**Addendum No. 1**

RE: Contract # C204603

**Alamance County (I-5711)**

I-40/I-85 AND SR-1007 (MEBANE OAKS RD) IN MEBANE.

PROJECT REFERENCE NO. 1-5711 SHEET NO. 5  
ROADWAY DESIGN 2/22/2011 ENGINEER HYDRAULICS 2/22/2011 ENGINEER  
NORTH CAROLINA PROFESSIONAL SEAL 25523  
NORTH CAROLINA PROFESSIONAL SEAL 20147  
DOCUMENT NOT CONSIDERED FINAL UNLESS ALL SIGNATURES COMPLETED

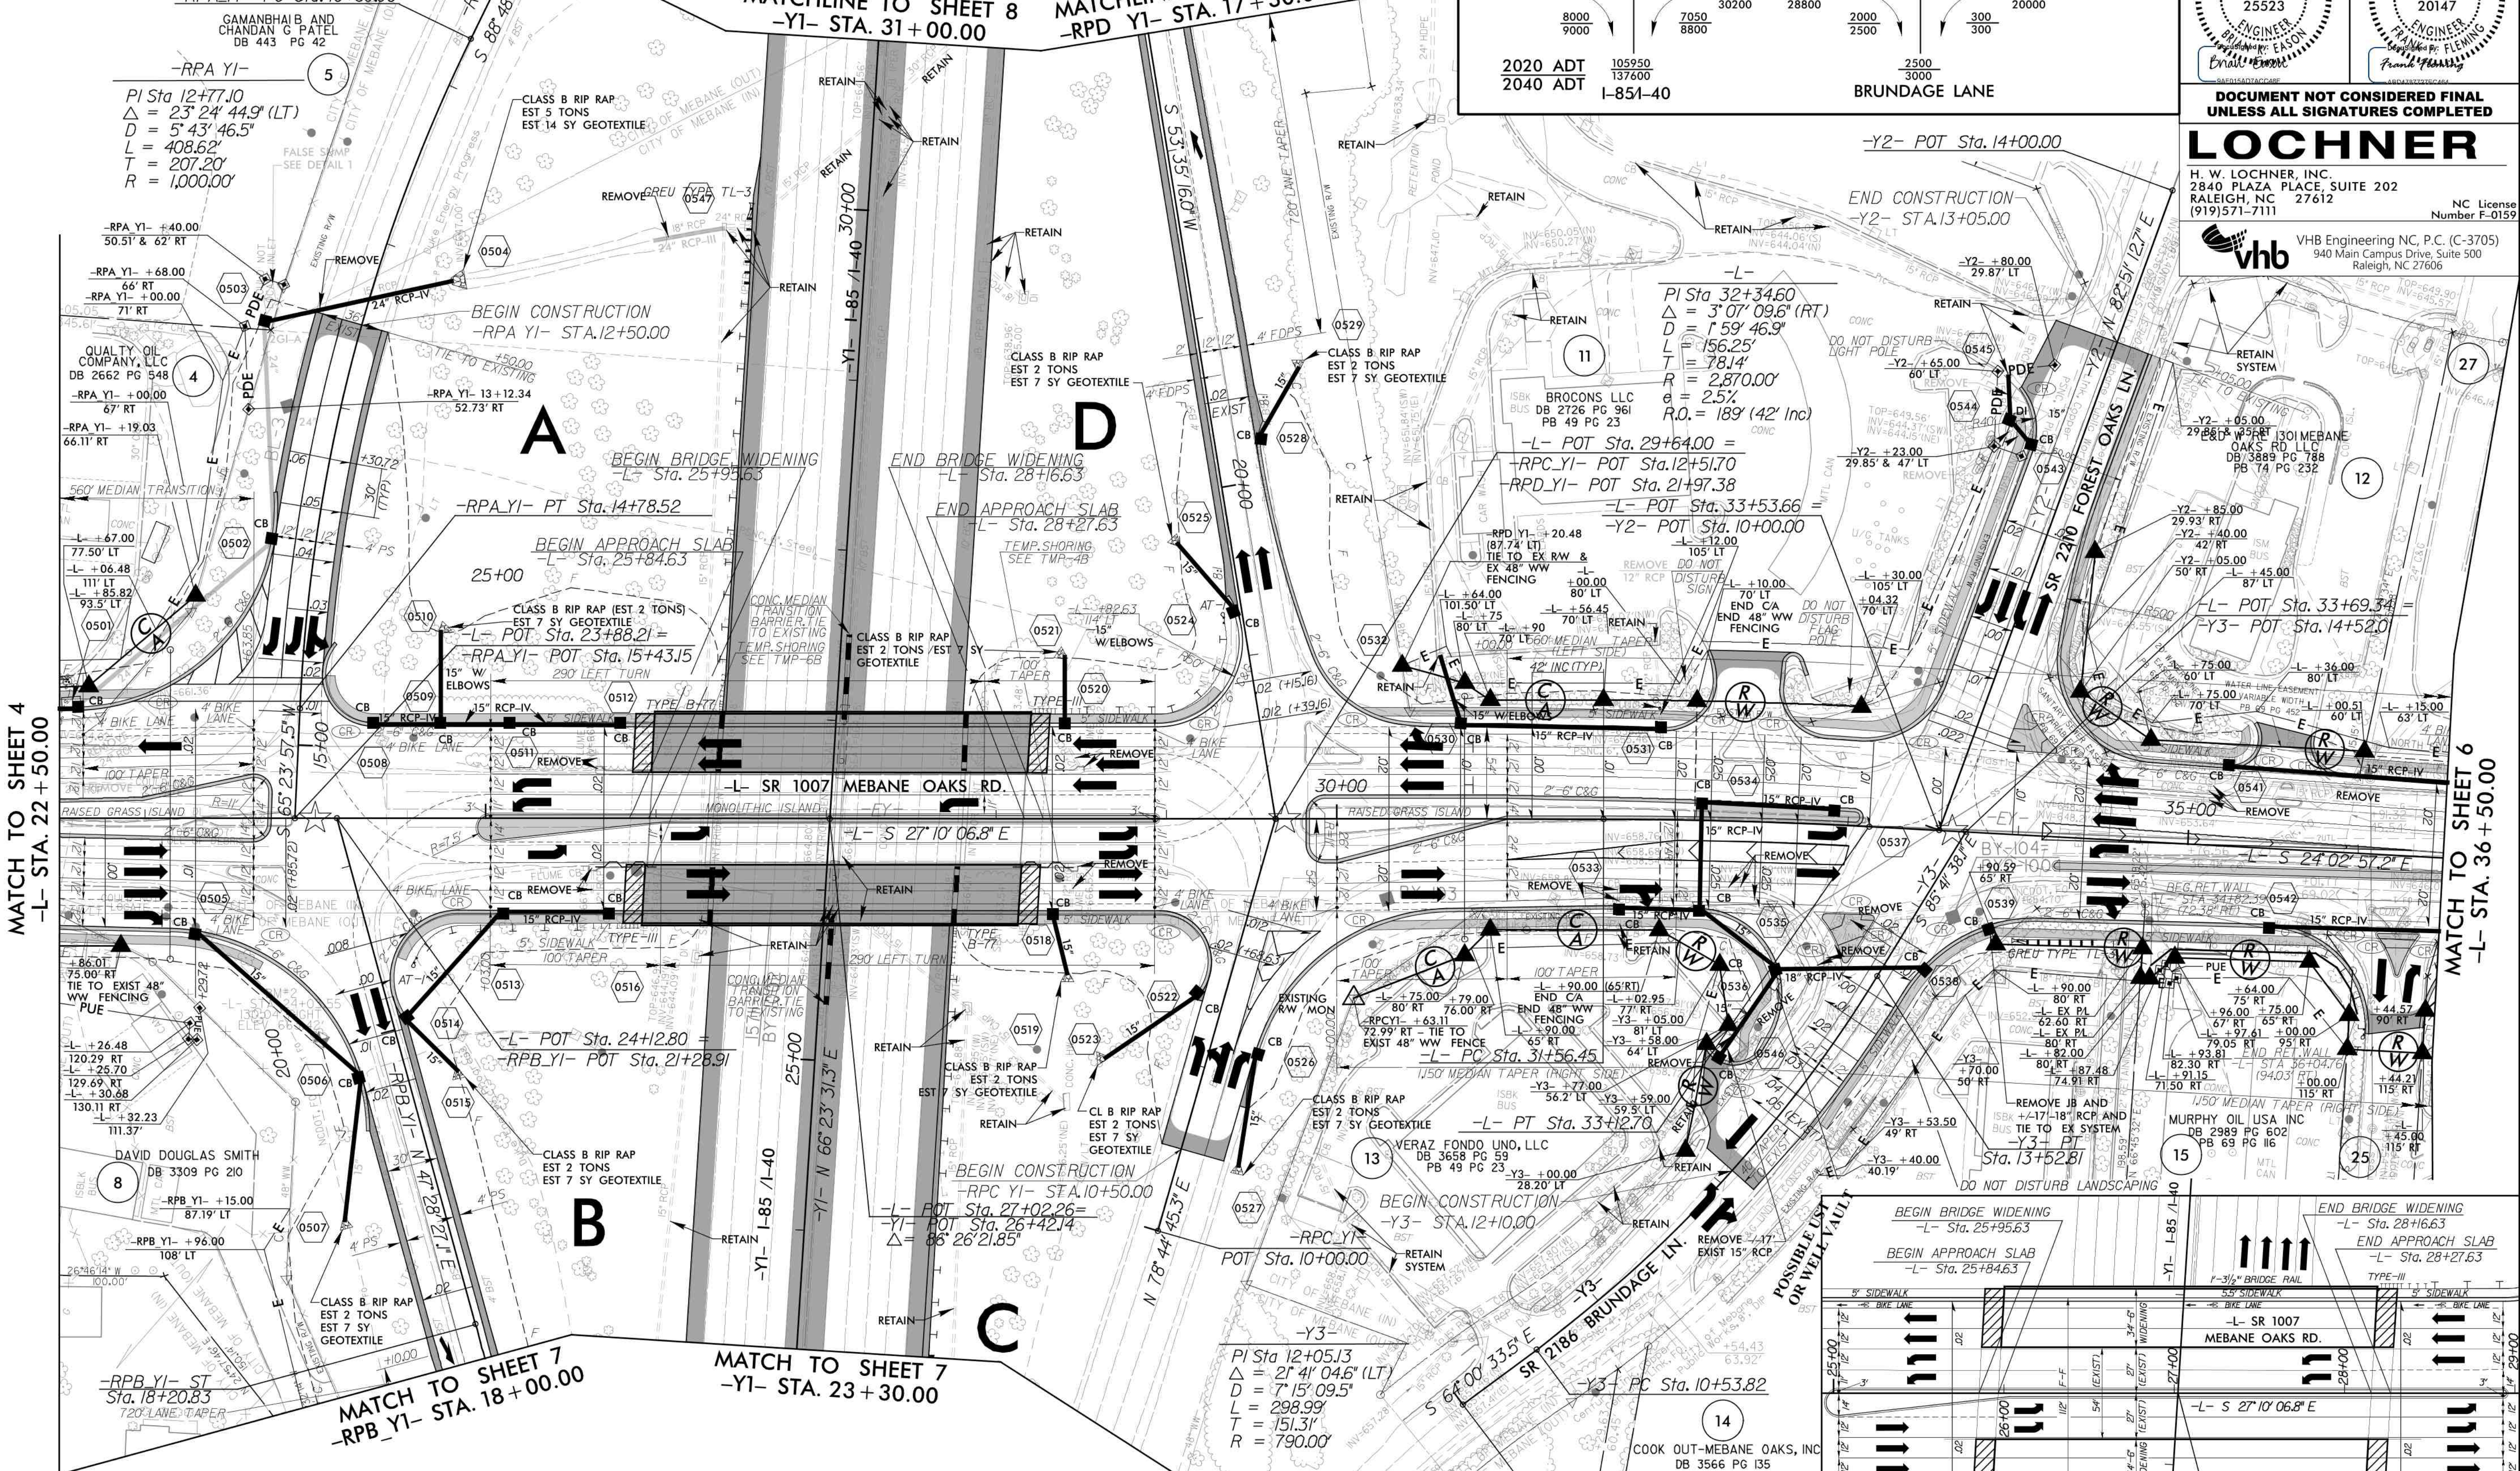
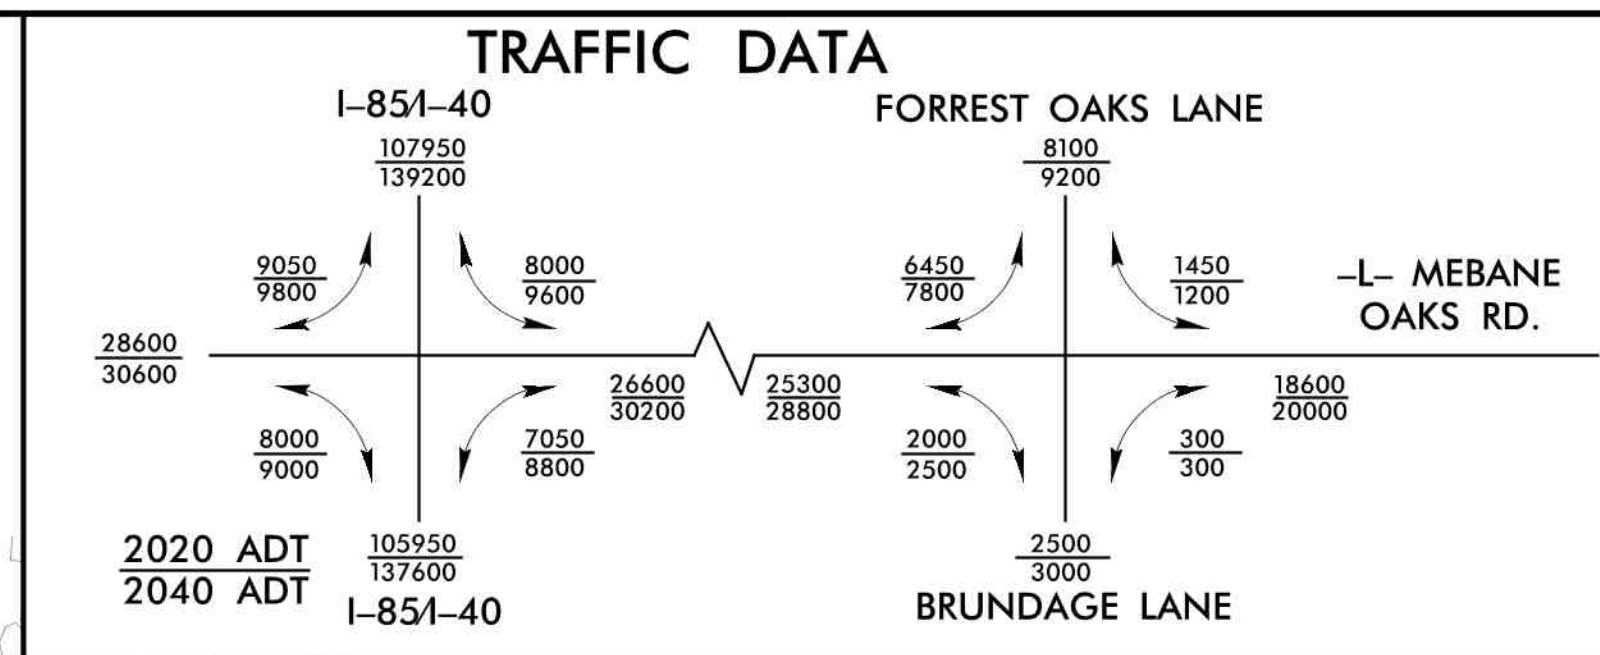
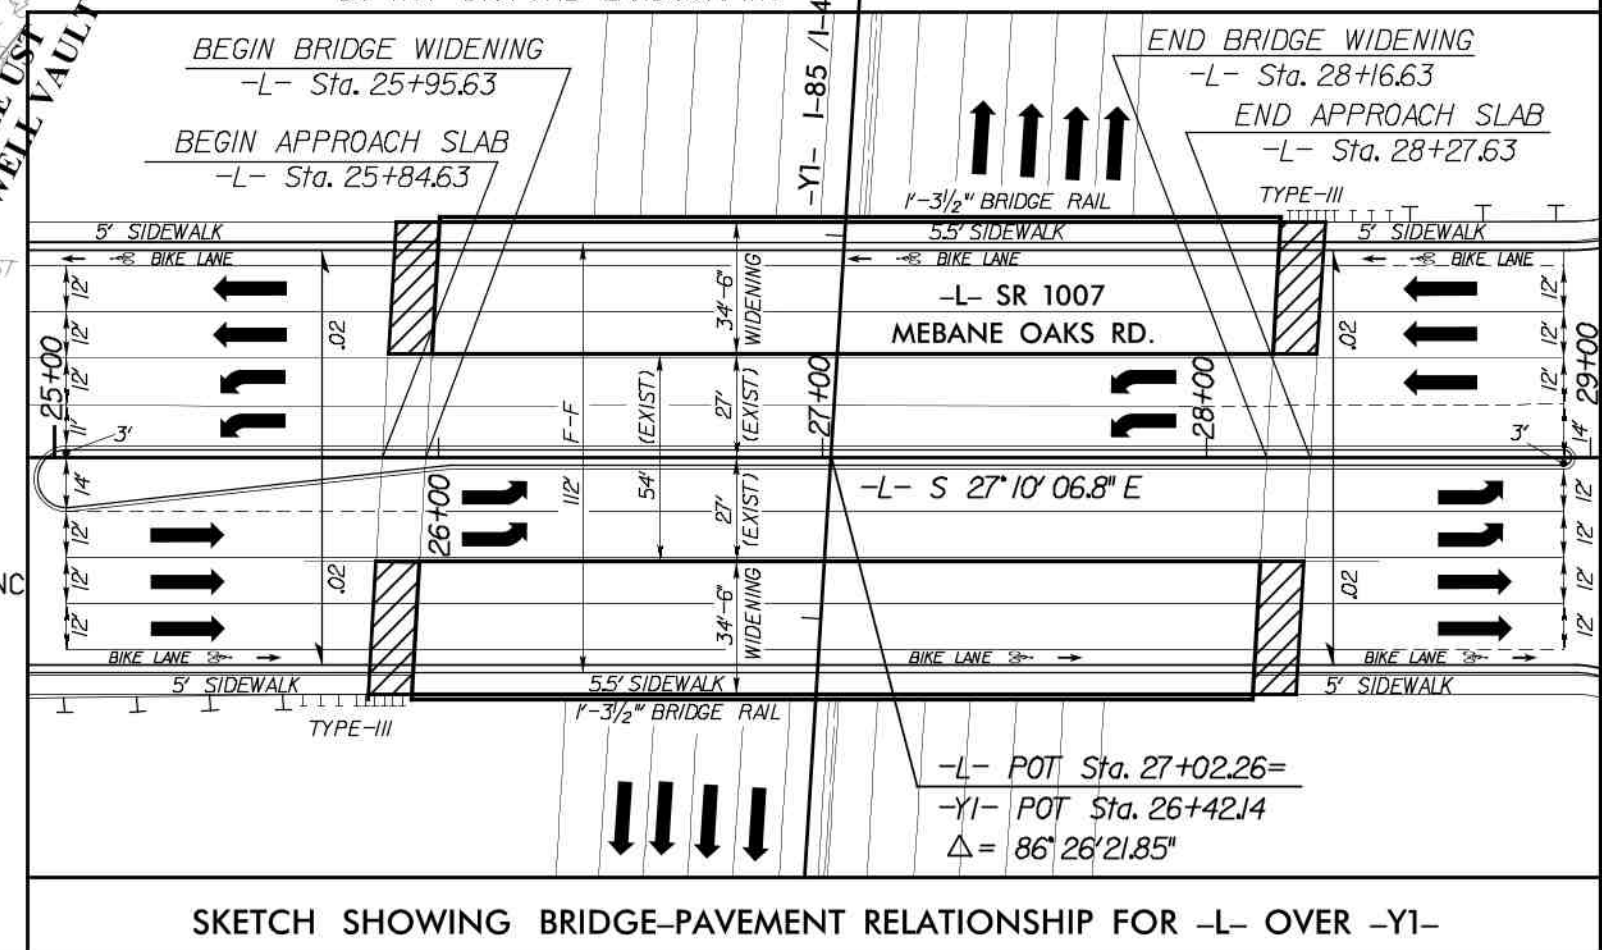
Sheet No.	Revision
5	<p><b>Parcel 4:</b> Moved R/W Monument on RPA_Y1 to intersect Existing R/W Line.</p> <p><b>Parcel 4:</b> Revised R/W Tag of RPA_Y1 from +18.01/Exist R/W to +19.03/66.11' Rt</p> <p><b>Parcel 15:</b> Moved Proposed PUE Monuments to R/W and extended Prop PUE Lines to intersect R/W. (PUE's were slightly extended inside R/W) (+/- 0.01')</p> <p><b>Parcel 15:</b> Revised mislabeled PUE monument tag from -L-+87.48/94.91 RT to -L-+87.48/74.91' RT</p>
6	<p><b>Parcel 18:</b> Revised PUE monument tag from -L-+61.71/61.00' RT to -L- +61.71/61.08' RT</p>
